Memorandum

September 9, 2014

Subject: CUATRO Senior Apartments
DRT# 14-010

NEW ARCHITECTURAL SITE KEY PLAN

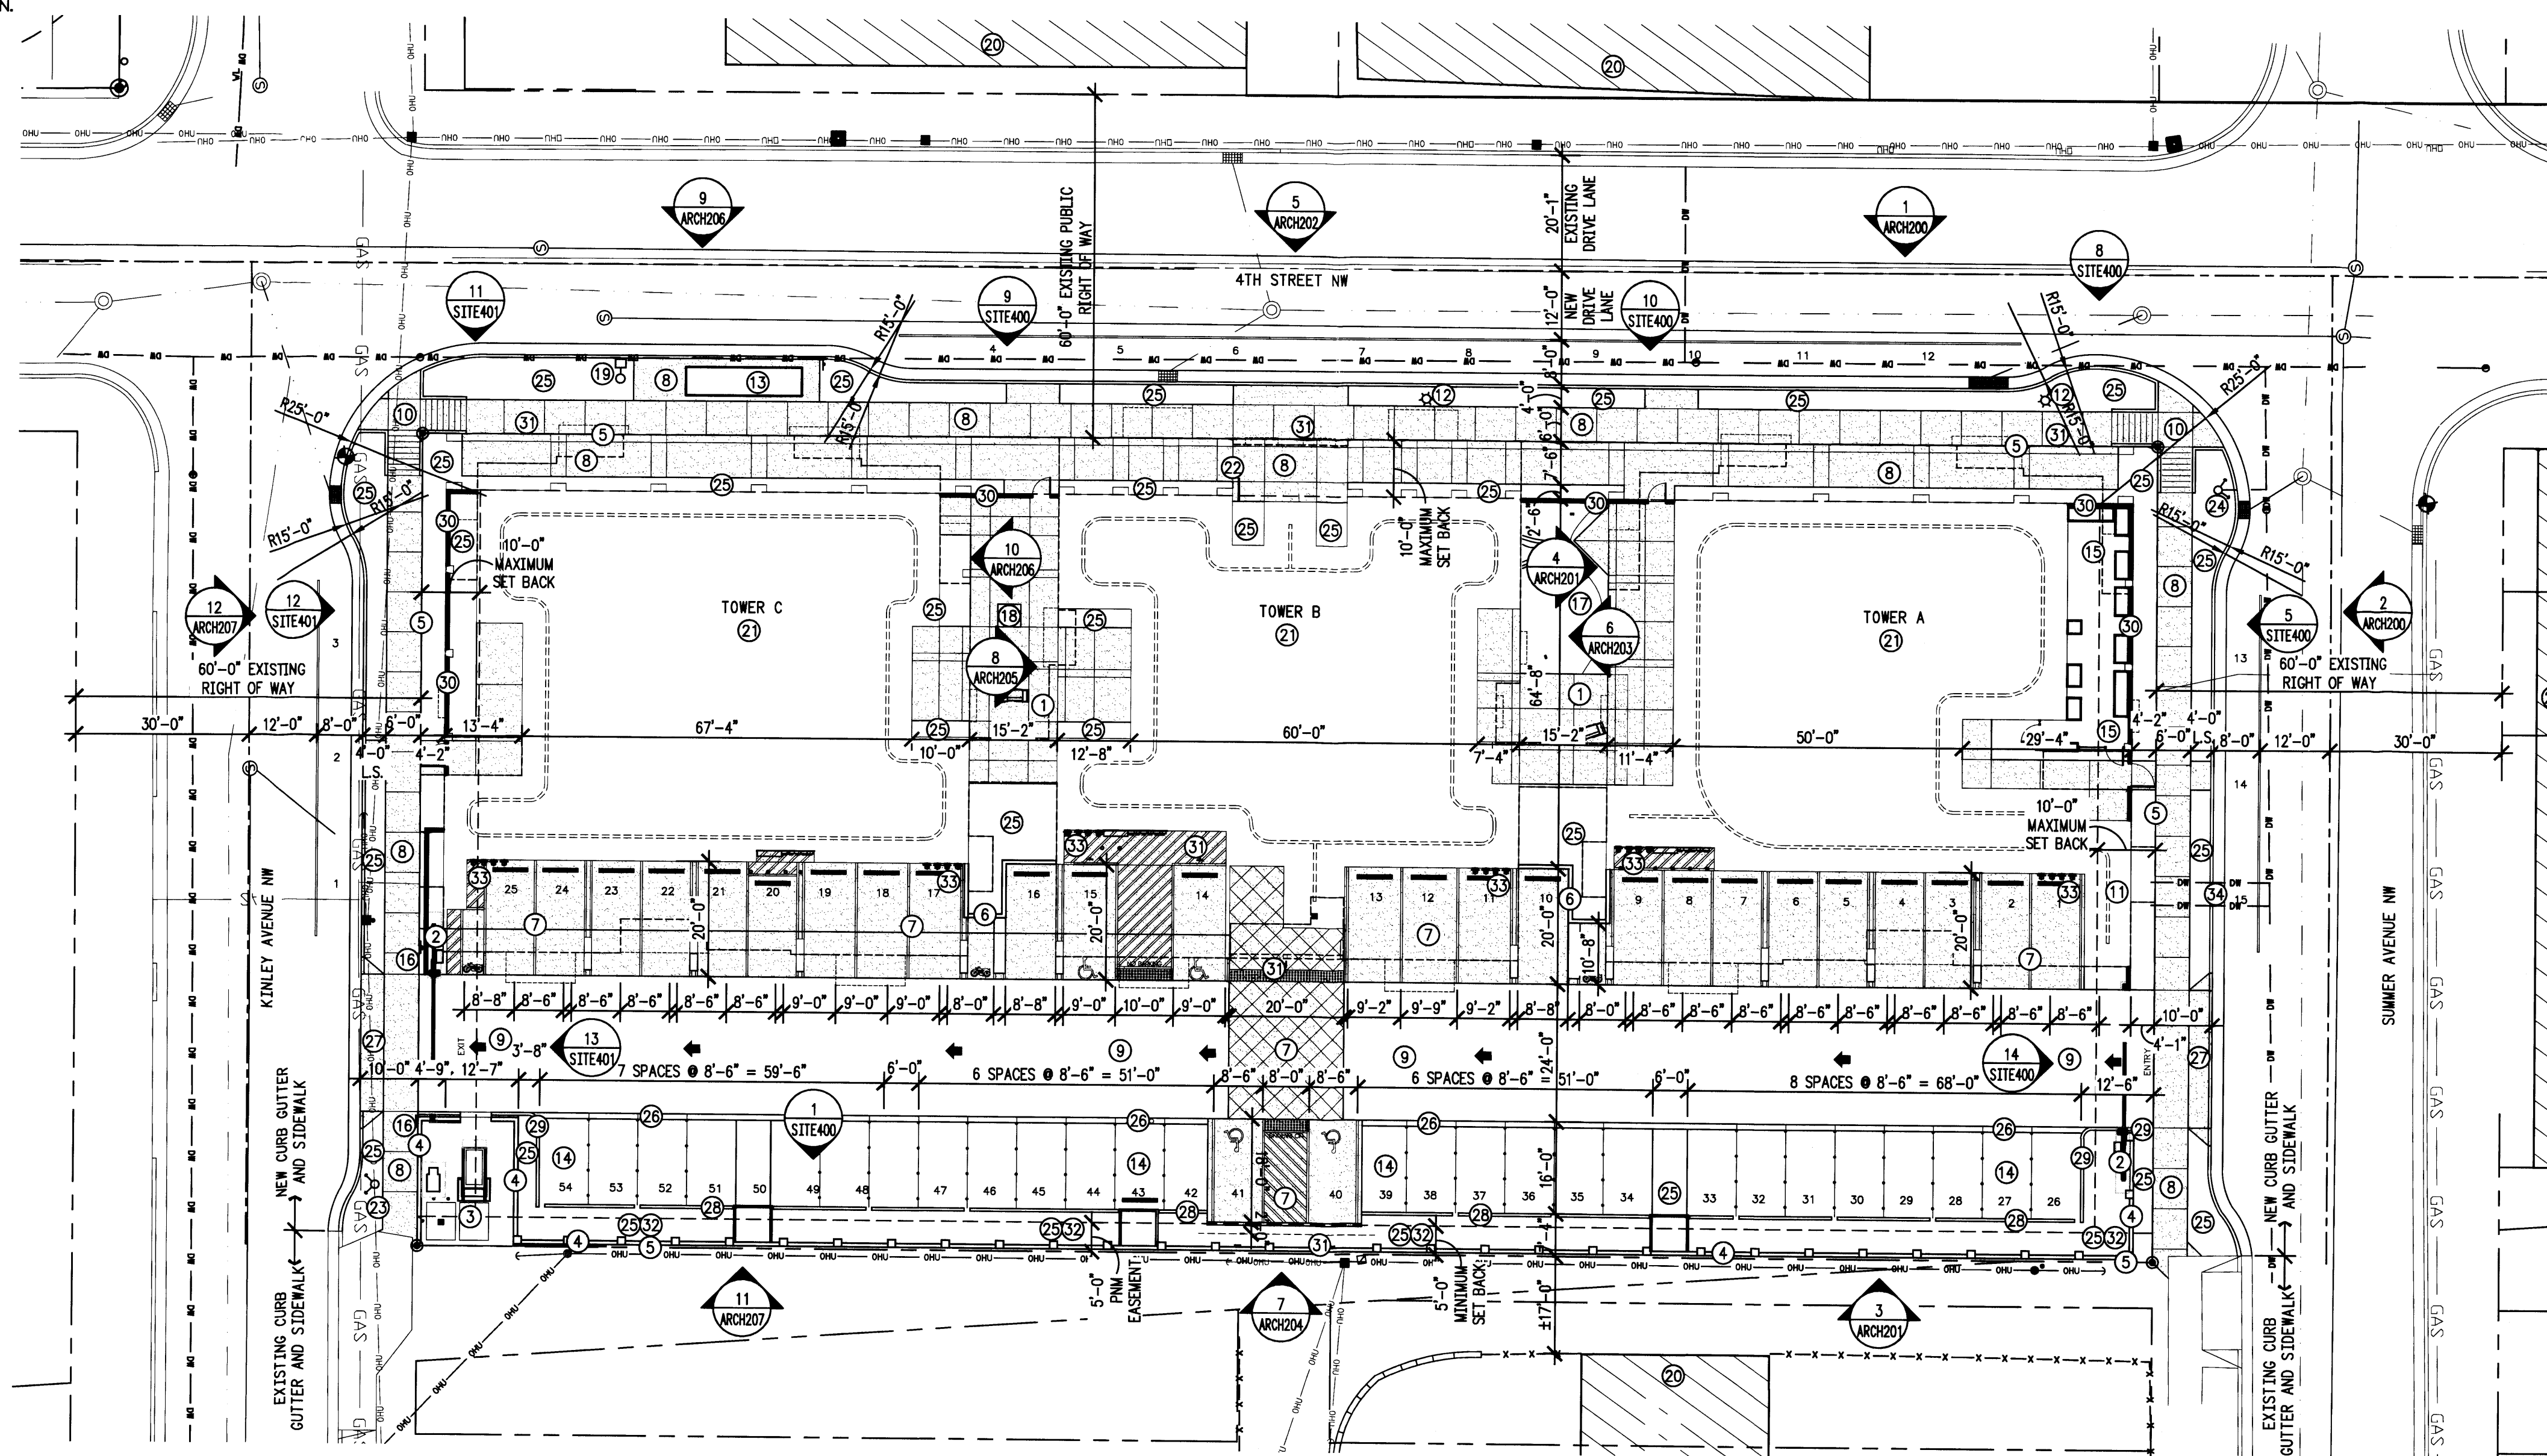
4. Parking

The applicant has requested consideration of a reduction in the required number of off street spaces by 4. There are 14 on street parking spaces abutting the site on the north, east, and south sides. According to the DPM, only 7 can be applied to the parking calculations. But, in essence, there are 7 additional spaces that can be used for this project. Also the project is a senior housing project located on a transit line (4th Street) which will reduce the need for vehicles. *Staff finds that the deviation to the required parking is in substantial conformance with the Plan.*

EAST & SOUTH EXT. ELEVATION-TOWER A

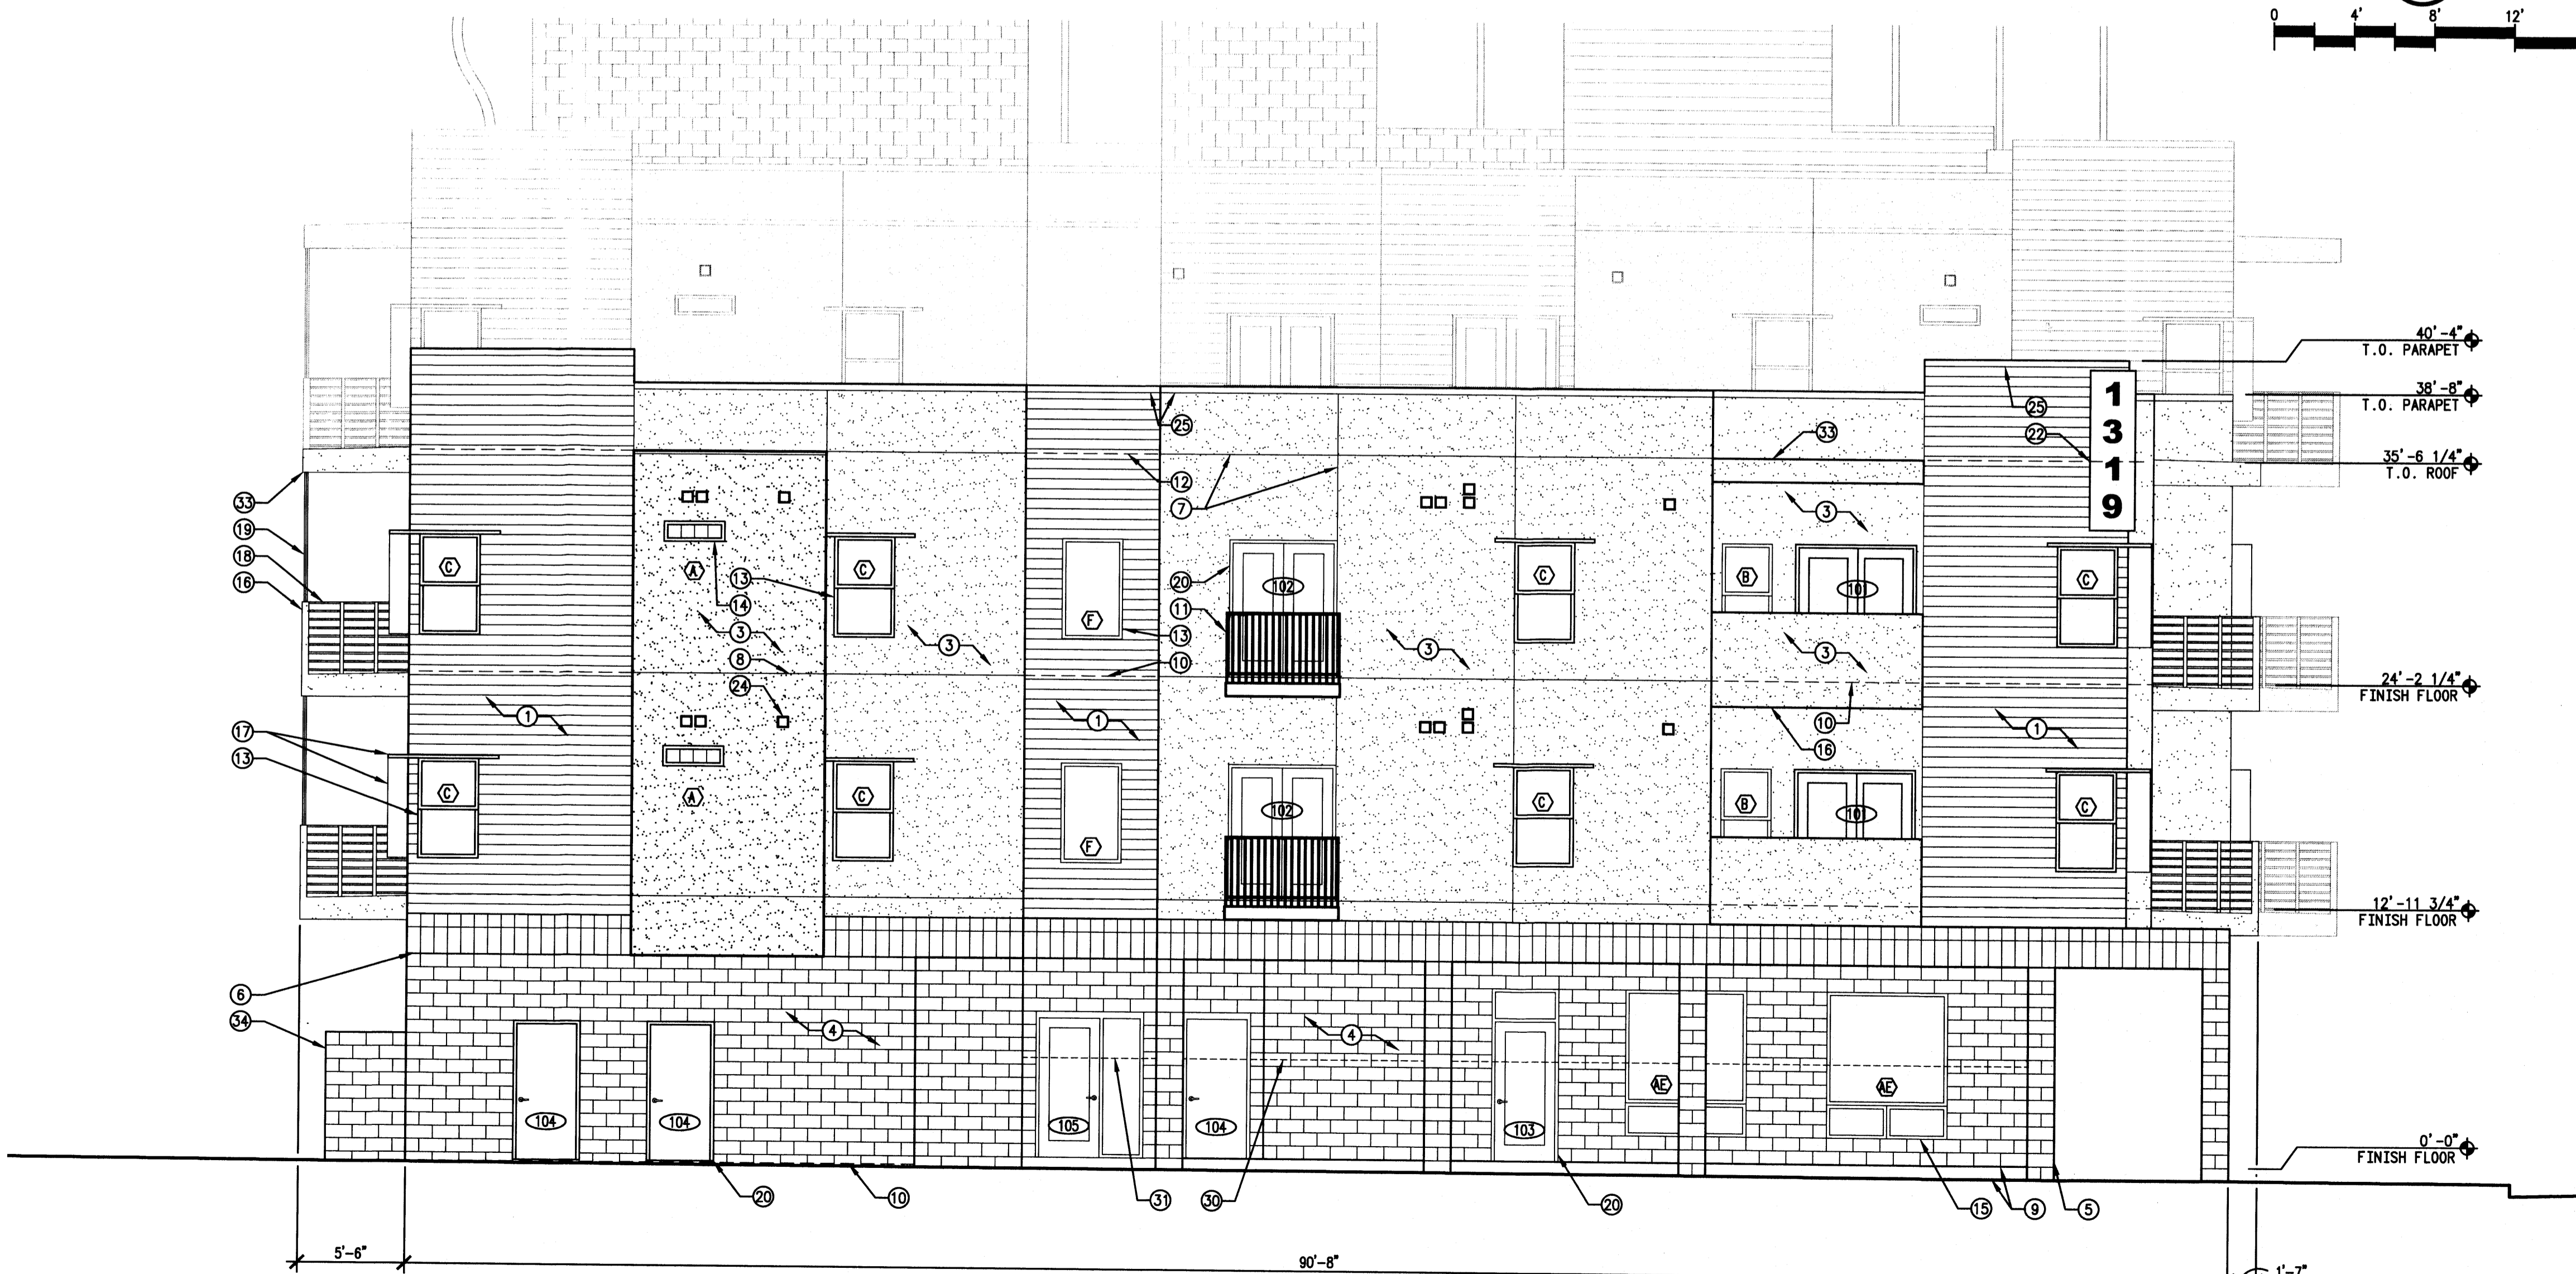
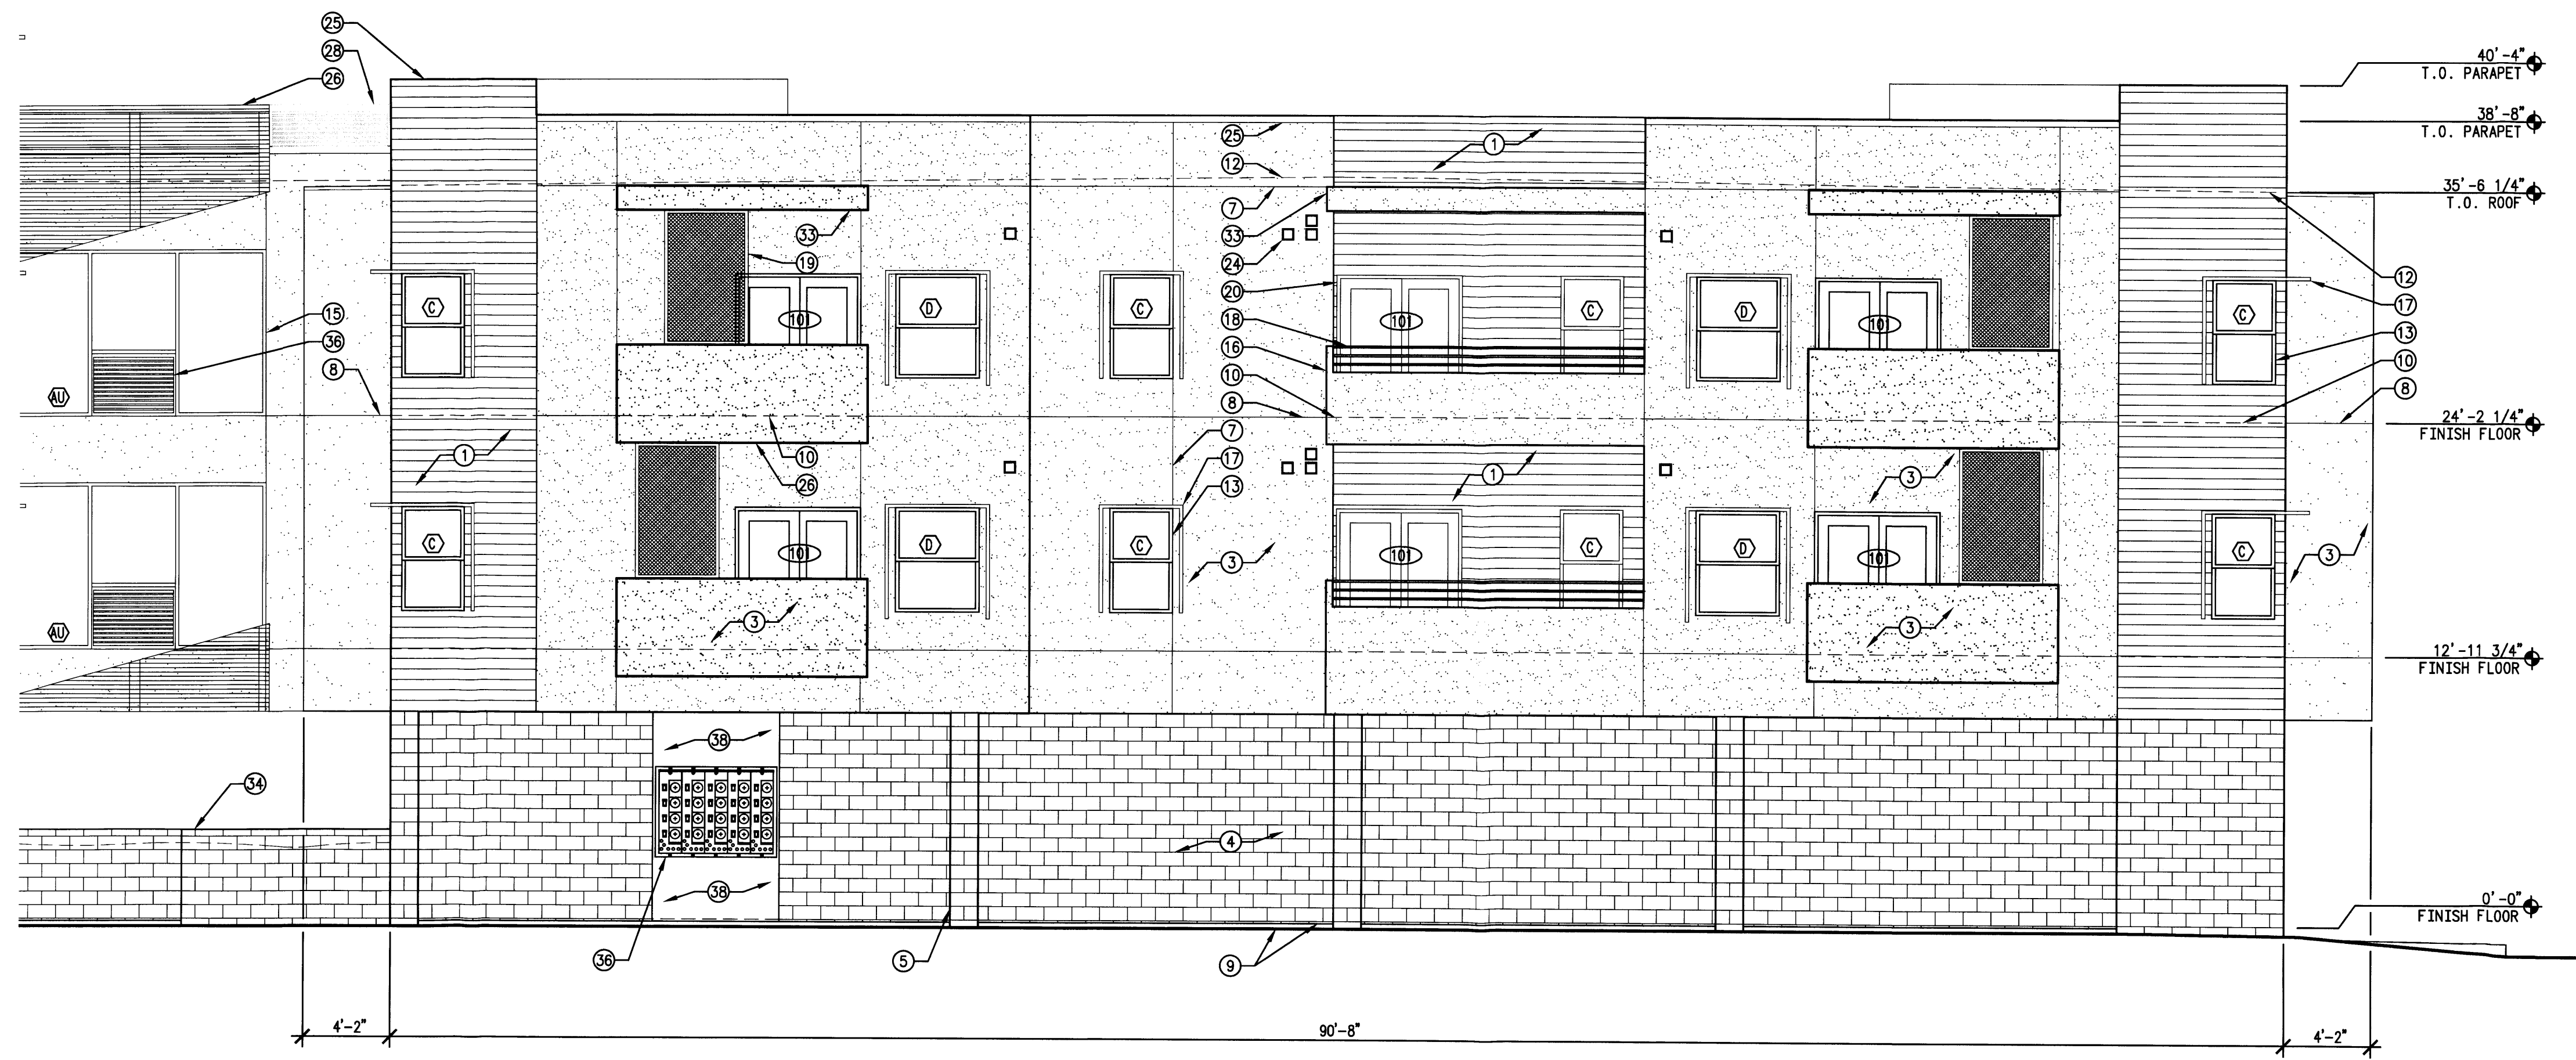
5. Building Articulation

The Plan requires that any proposed projects are designed using one type of the building forms (section 3.9 of the Plan). This project is designed using the Flex Building form. This building type requires that the facades of the building facing a public street, which is longer than 50 feet, must be articulated at a maximum of every forty feet along the street. It also requires that Entryways be located every 40 feet along the front façade. The proposed project has an entry at the middle of the building and two openings at the ground floor that are secured with a gabion wall and metal fencing. While these are not open entries, they accomplish the intent by offering articulation, but allowing security to the complex, which is a concern in a senior housing project. *Staff finds that the deviation is in substantial compliance with the Plan.*
